**Consultation Response from KC,  
Trees****2024/93237 adj, 14, Whinmore Gardens, Gomersal, Cleckheaton, BD19 4HG****Erection of detached dwelling****Date Responded: 03/12/2024****Responding Officer: JD****Responding Ref: 47/80**

PROPOSED SITE PLAN
1:100@A2

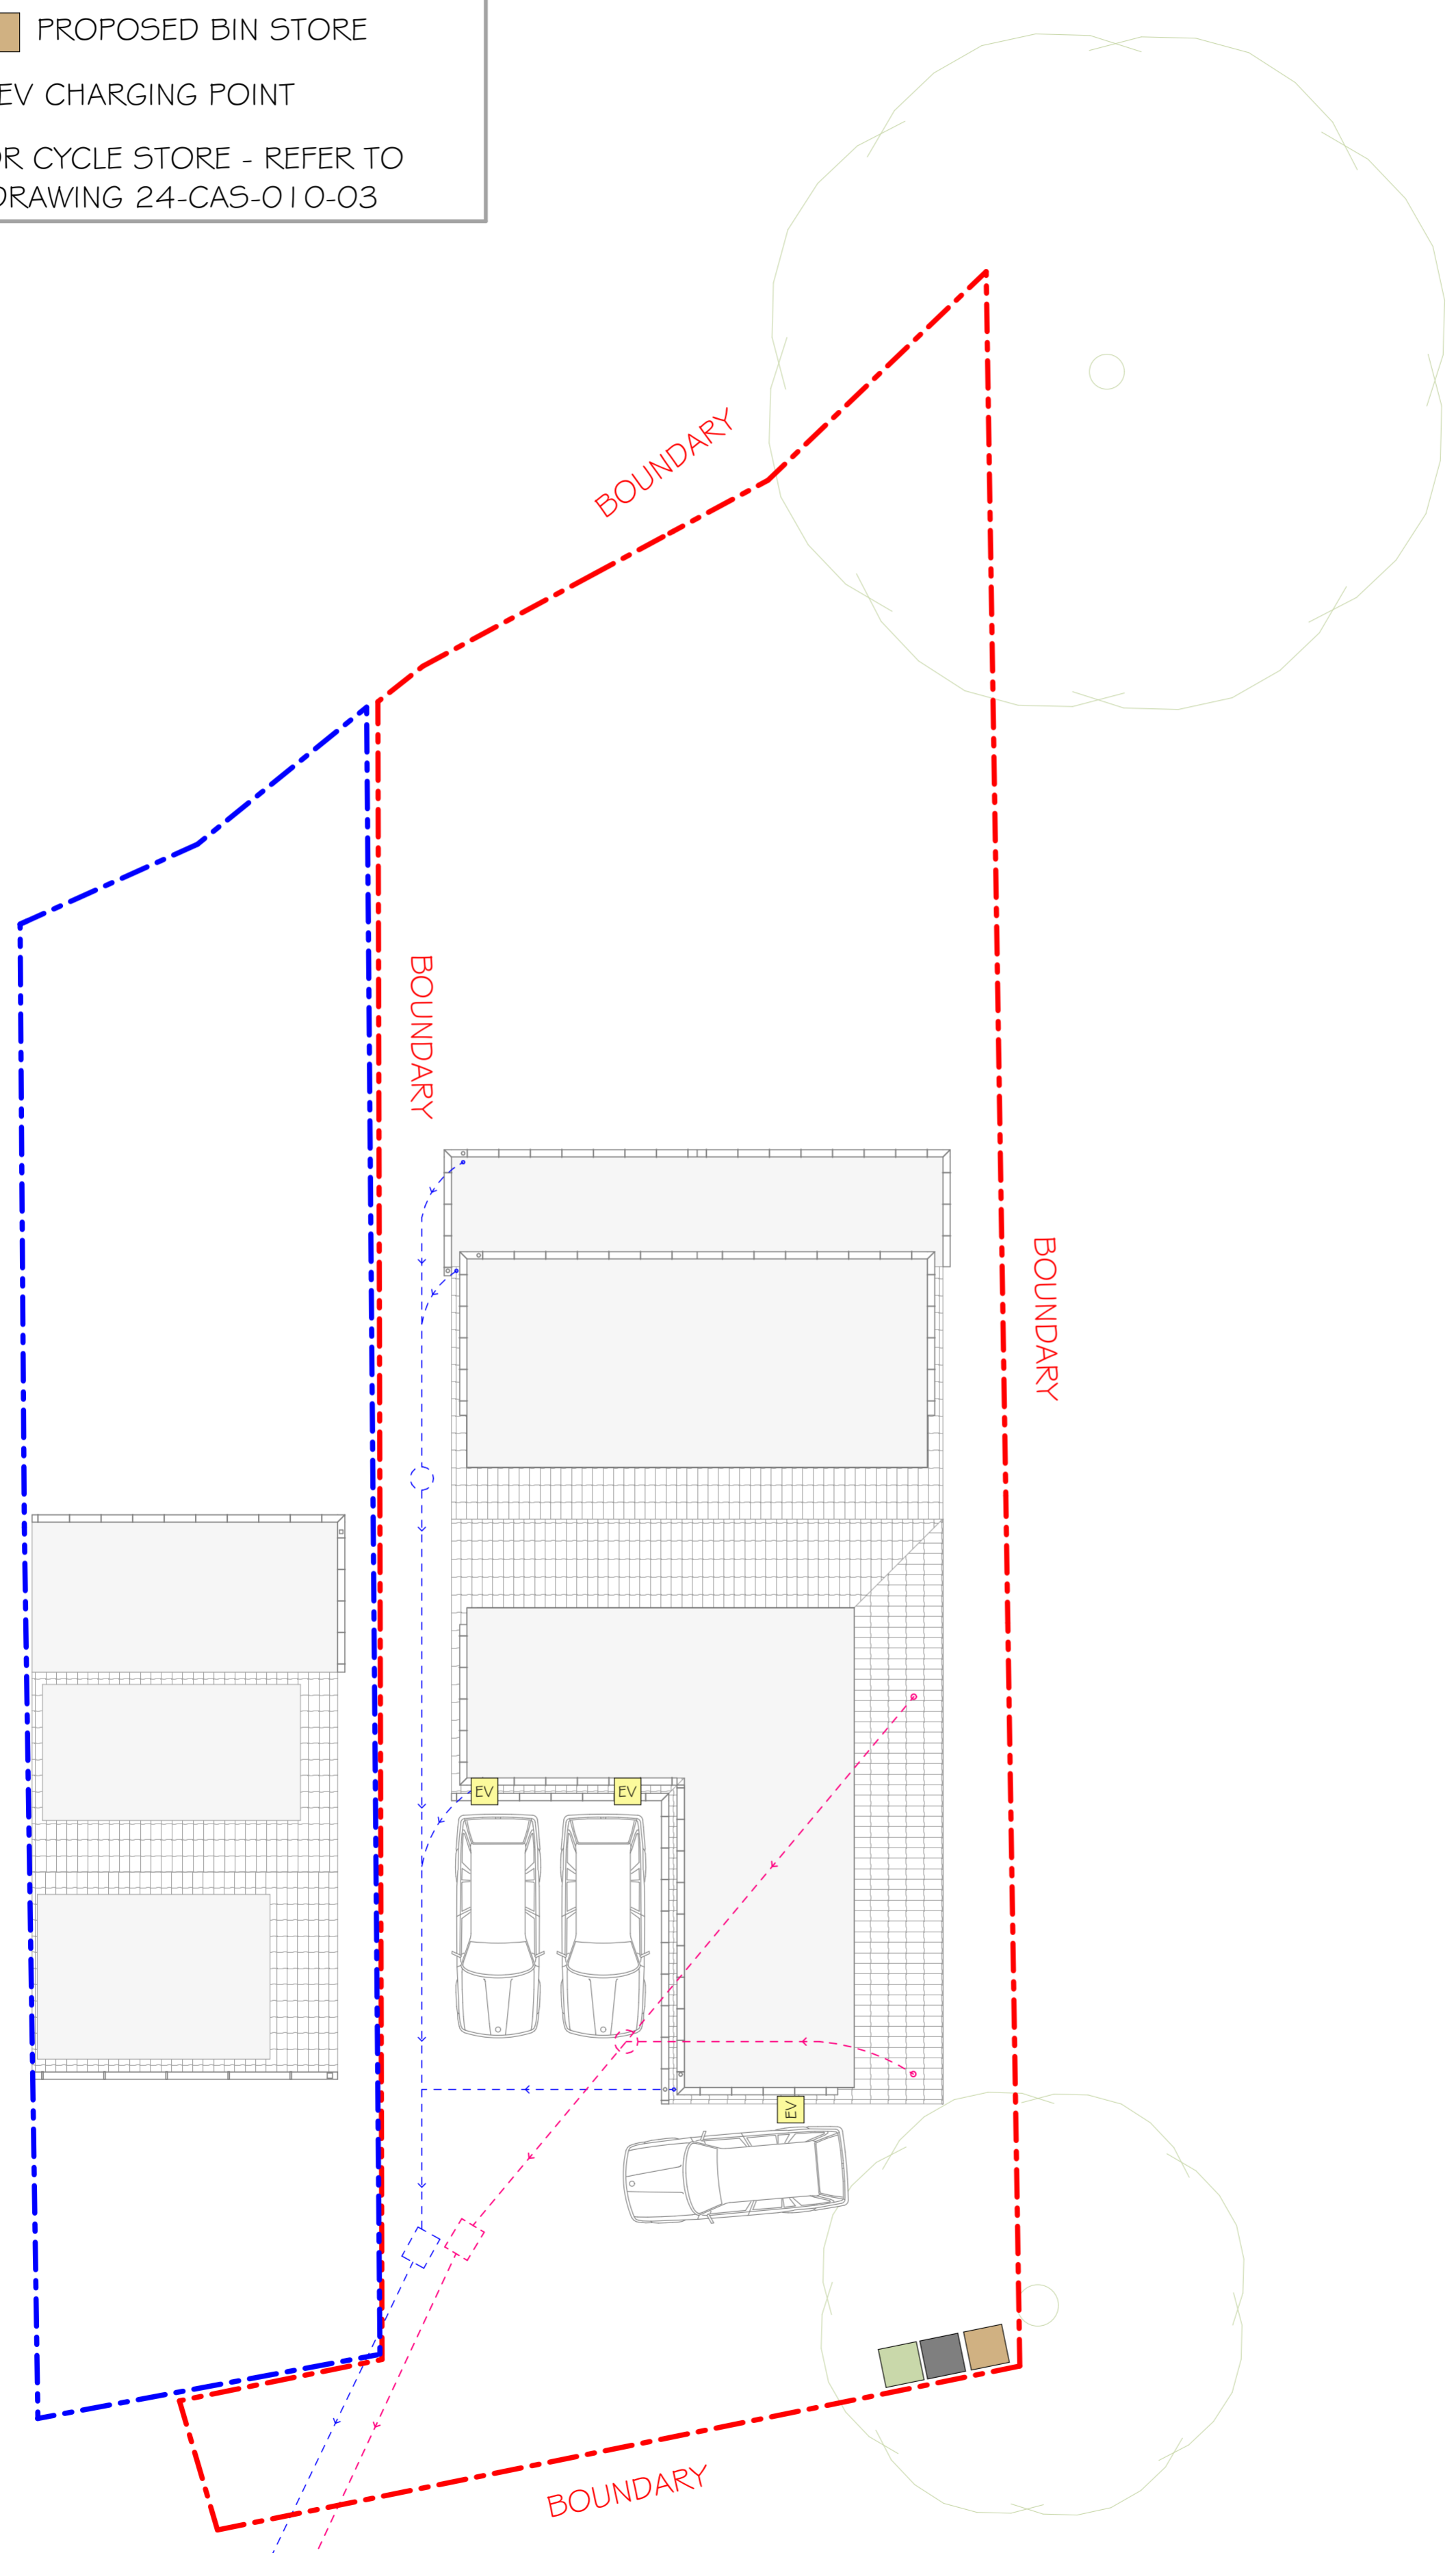
Due to the trees being south facing the property is likely to be cast in shade for the majority of the day. This may lead to future pressure to have the trees pruned or even removed. This should be a material consideration prior to construction as consent for tree works is unlikely to be given for alleviating shade.

On the whole there is no objection to the proposals providing a condition for a detailed Arboricultural Method statement (AMS) is submitted and agreed by the LPA prior to construction starting. The AMS must reflect the advice given in the AIA precisely as there is potential for damaging these protected trees should it not be followed.
